24/00045/FUL
25.01.2024

**RSA HOUSE, WESTERN ROAD, BRACKNELL, BERKSHIRE, RG42 1RX
SECTION 73 OF THE TOWN AND COUNTRY PLANNING ACT 1990: APPLICATION FOR A MINOR-
MATERIAL AMENDMENT IN RELATION TO PLANNING PERMISSION REF: 22/00879/FUL**

DRAWING NO. 19103 - SK29 REV A

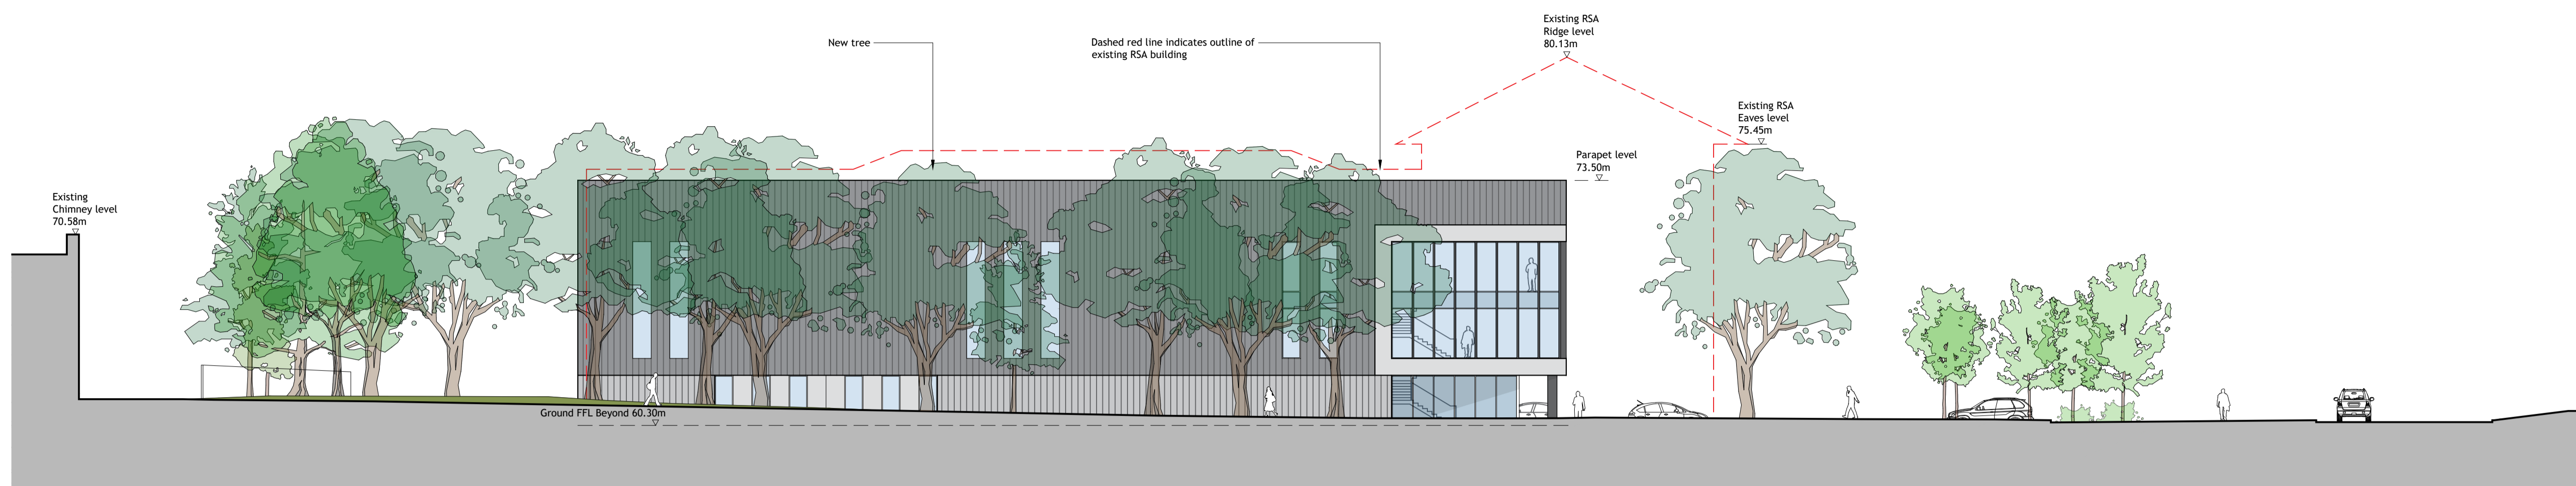
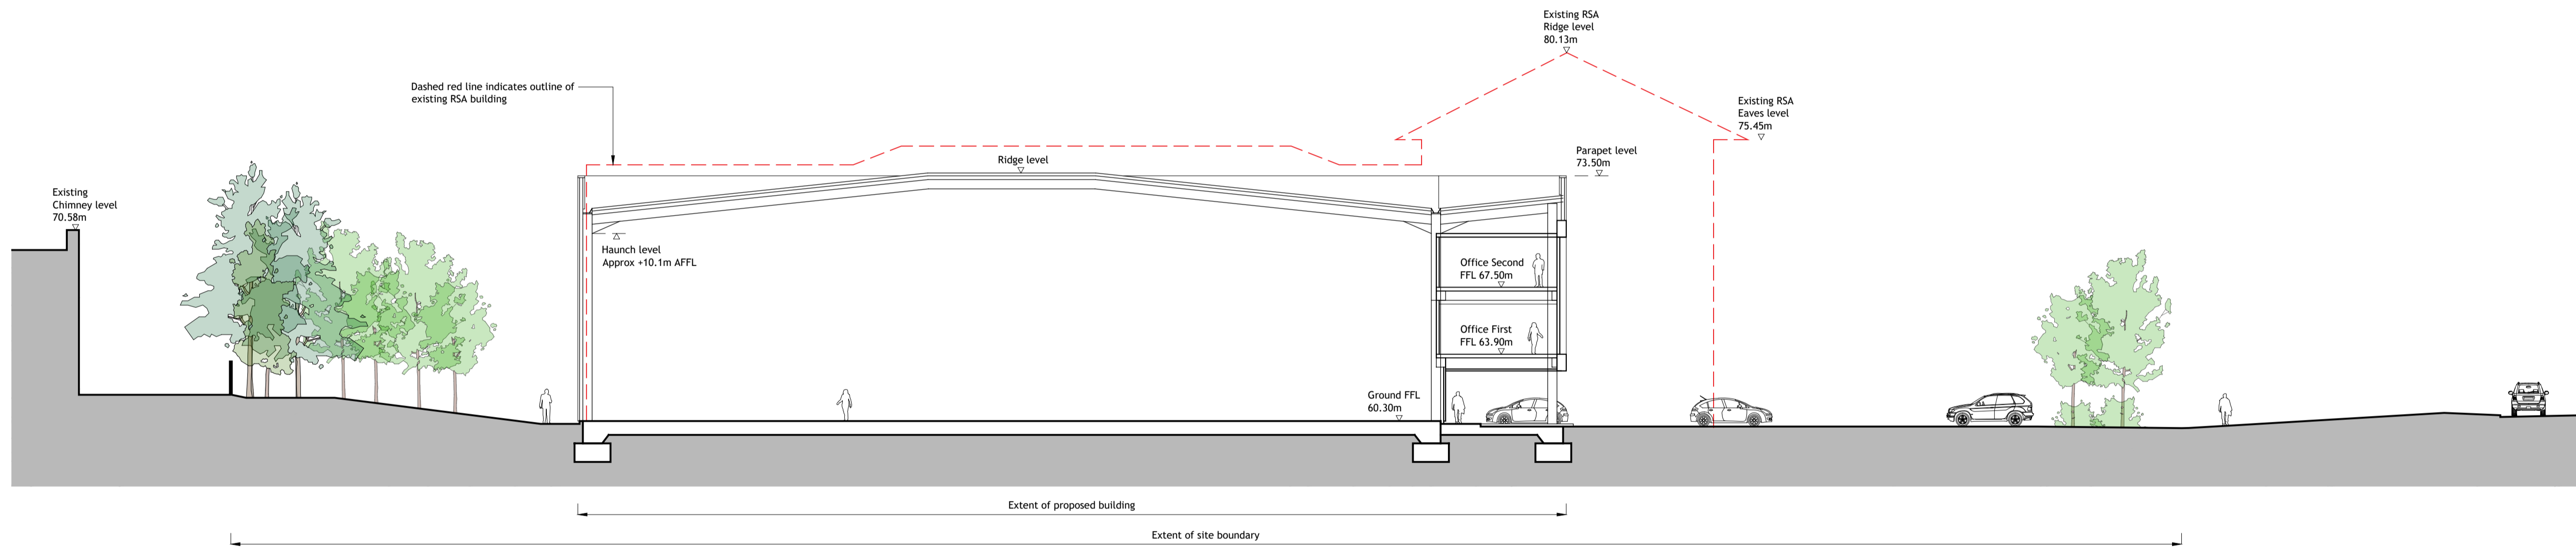
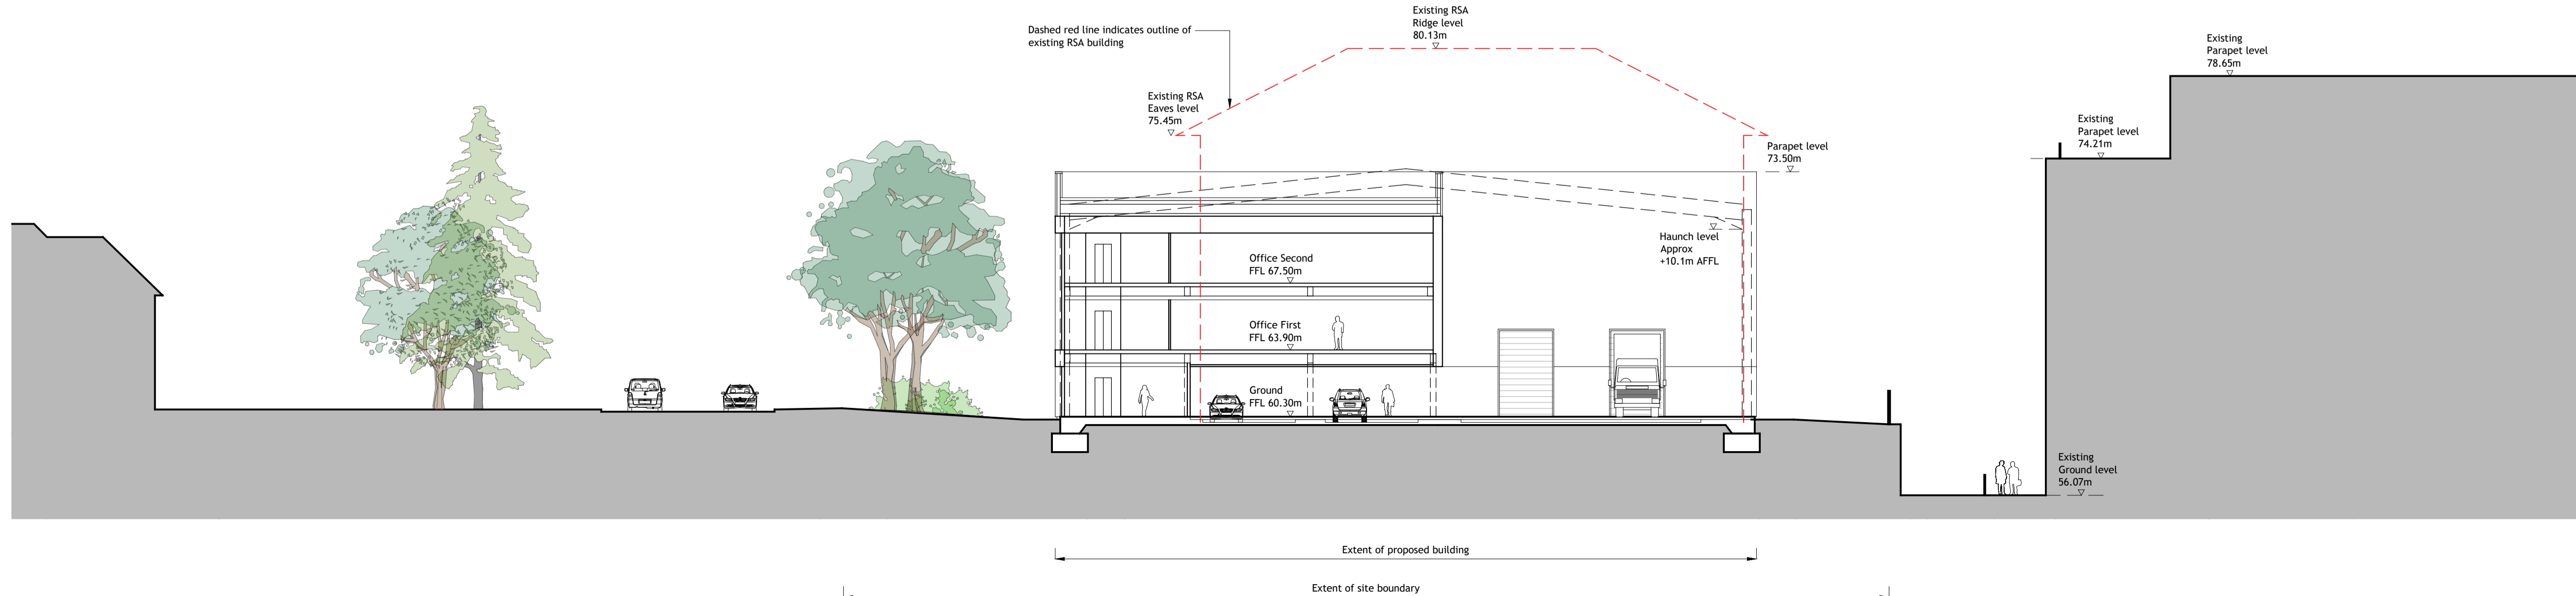
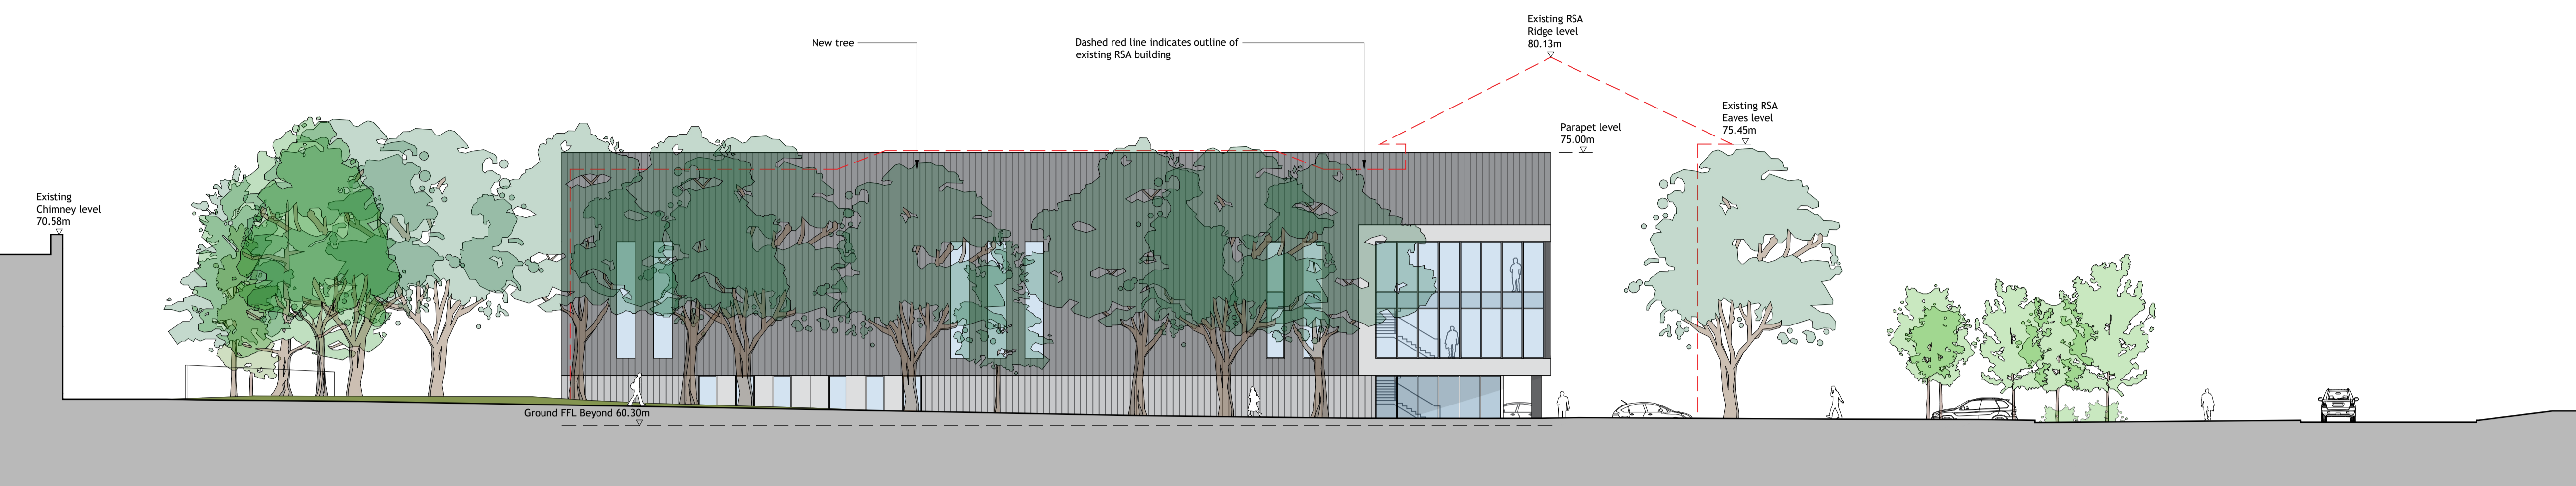
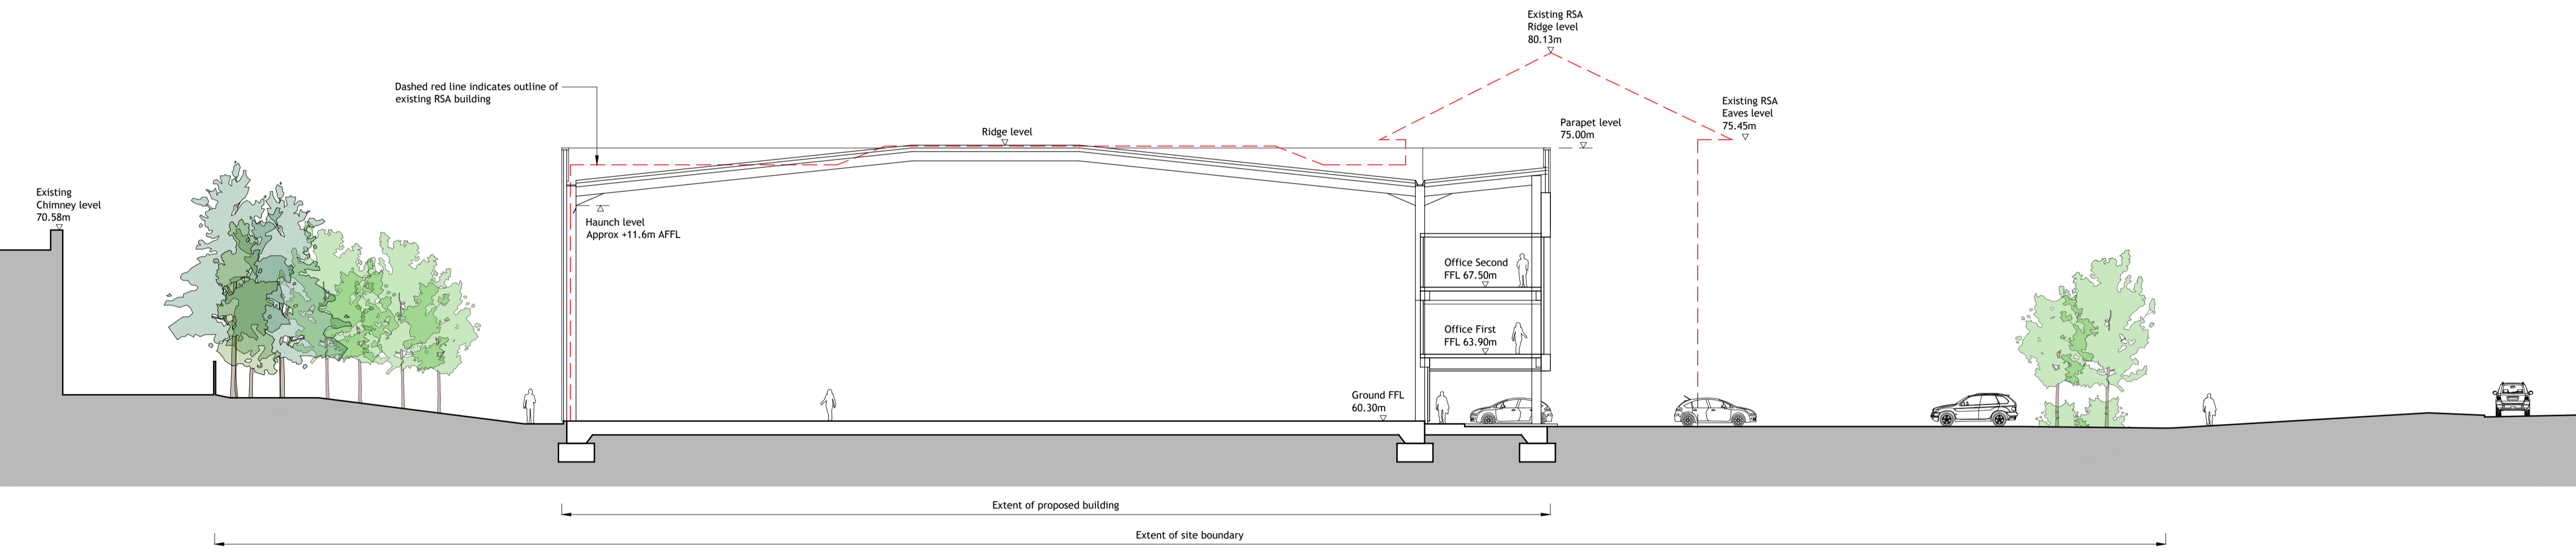
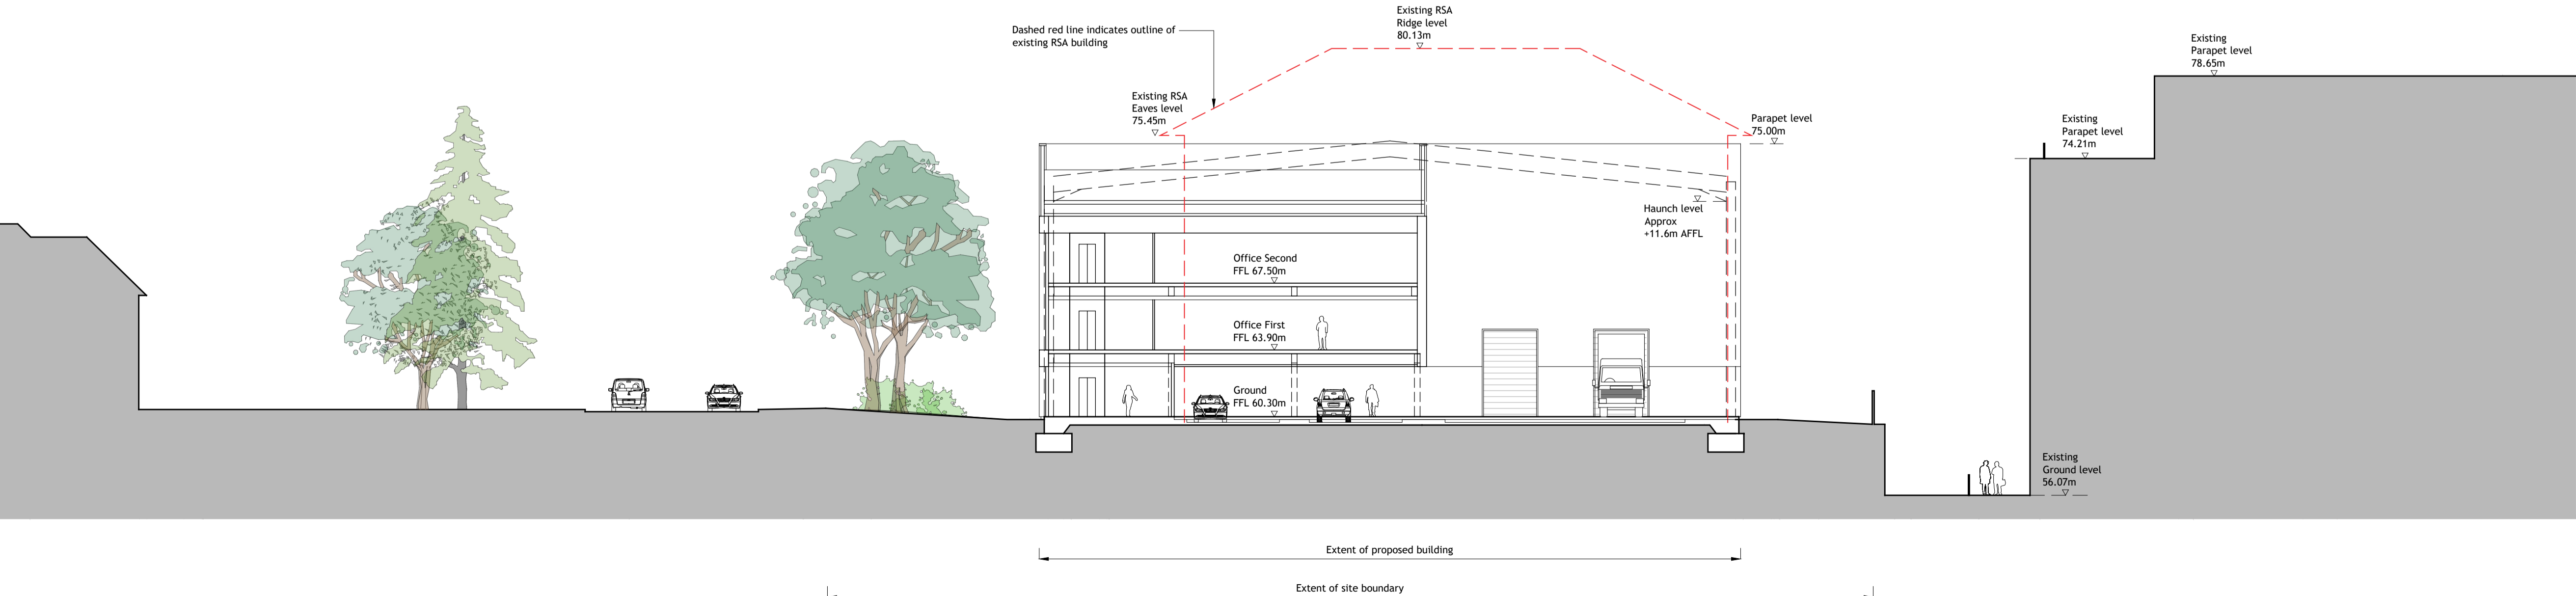
The Applicant has been marketing the Site to potential occupiers for a considerable amount of time with limited success. Tentative demand has emerged recently and the Applicant has engaged in comprehensive discussions with a potential occupier. However, as part of the discussions the potential occupier has stated they would require an increase in height of the building by 1.50m to progress discussions further, therefore taking the overall eaves height of the building from 13.2m to 14.7m.

Drawing Title	Approved Drawing Reference (drawings to now be superseded)	Proposed Drawing Reference (to supersede Approved Drawings)
Proposed Site Sections	19103-SK29 Rev A	19103-SK34
Proposed Elevations	19103-SK30 Rev B	19103-SK35
Proposed Elevations	19103-SK32	19103-SK36

In the context of the above, it is considered the proposed 1.50m increase in height of the approved scheme represents a ‘minor material amendment’, and therefore, under Section 73 of the Town and Country Planning Act 1990, an application to vary the conditions under the approved decision notice represents the most appropriate planning route.
